REQUEST

Current Zoning: N1-B (Neighborhood 1-B)
Proposed Zoning: N2-A(CD) (Neighborhood 2-A, Conditional)

Approximately 4.1 acres located on the east side of South Tryon Street, west of Nations Ford Road, and north of Queen Anne Road.

The petition proposes to develop a vacant, wooded property in the S Tryon Street corridor with a community of up to 50 multi-family attached dwellings.

RZ-1.0

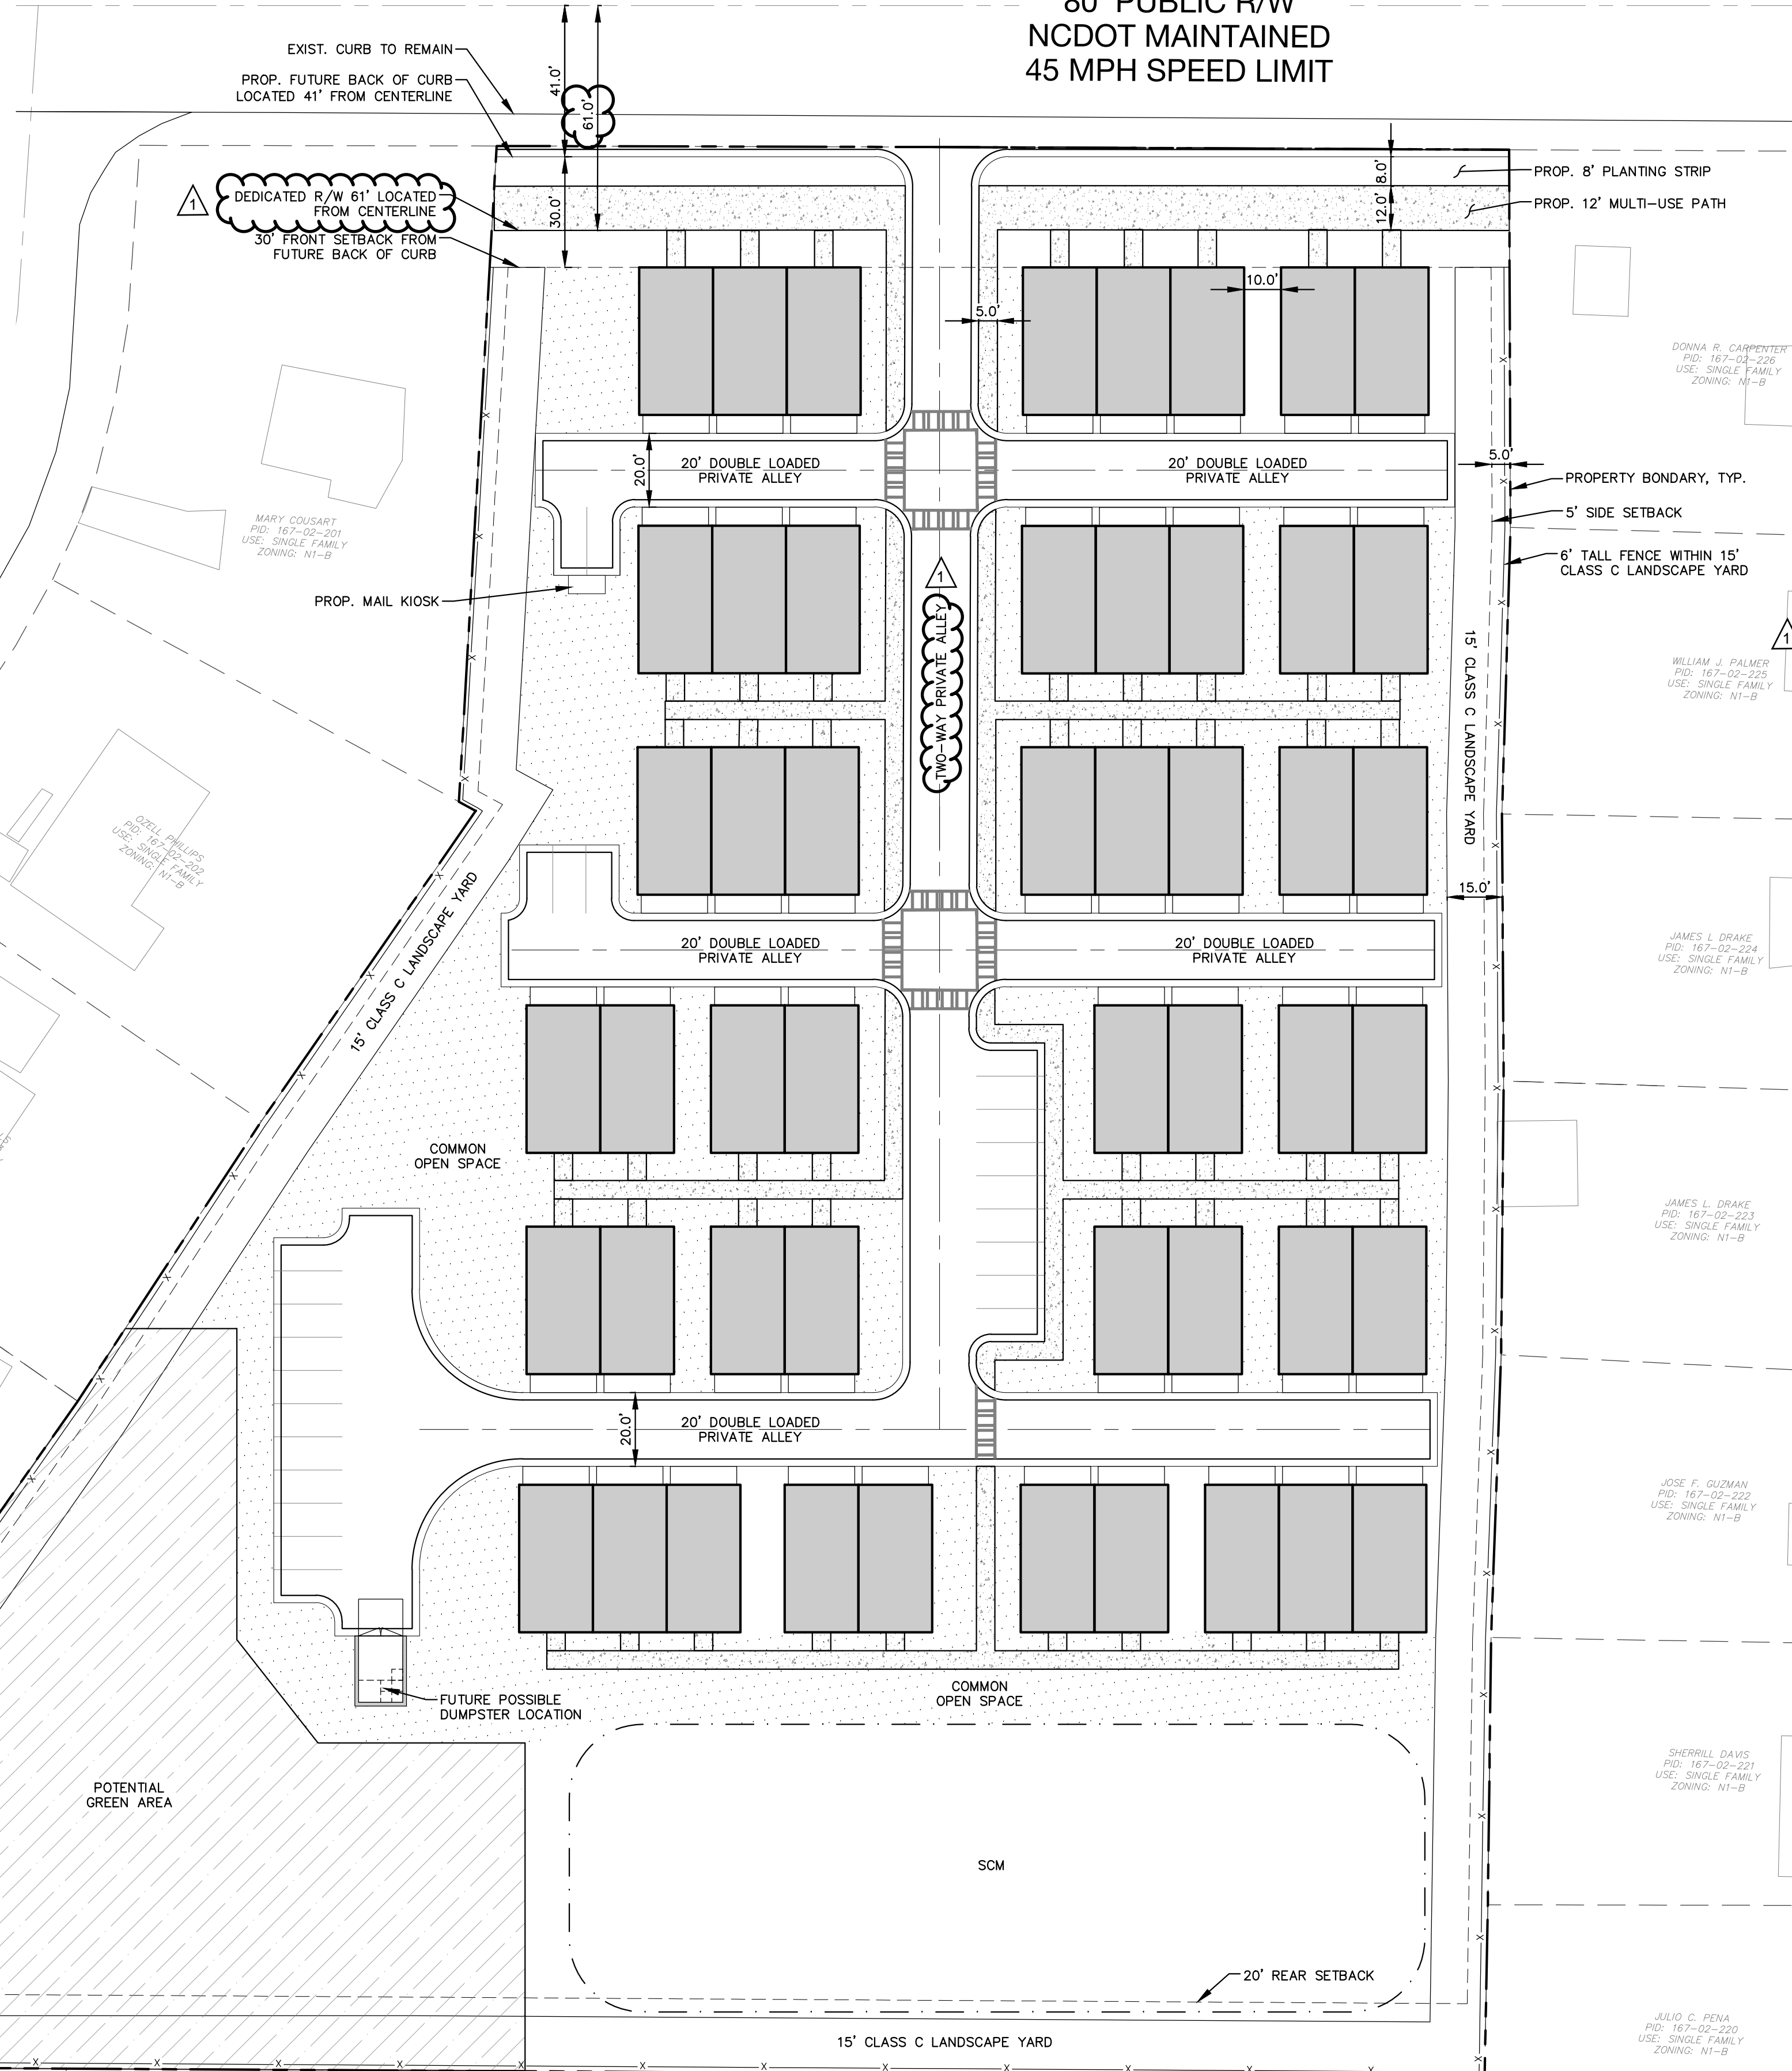
- ~~1. In coordination with NCDOT, revise site plan and conditional notes to install a right turn lane into the site with 50' of storage.~~ ADDRESSED
- ~~2. Use only one line to show future back of curb. Move the driveway cut and curb and gutter to the existing location.~~ ADDRESSED
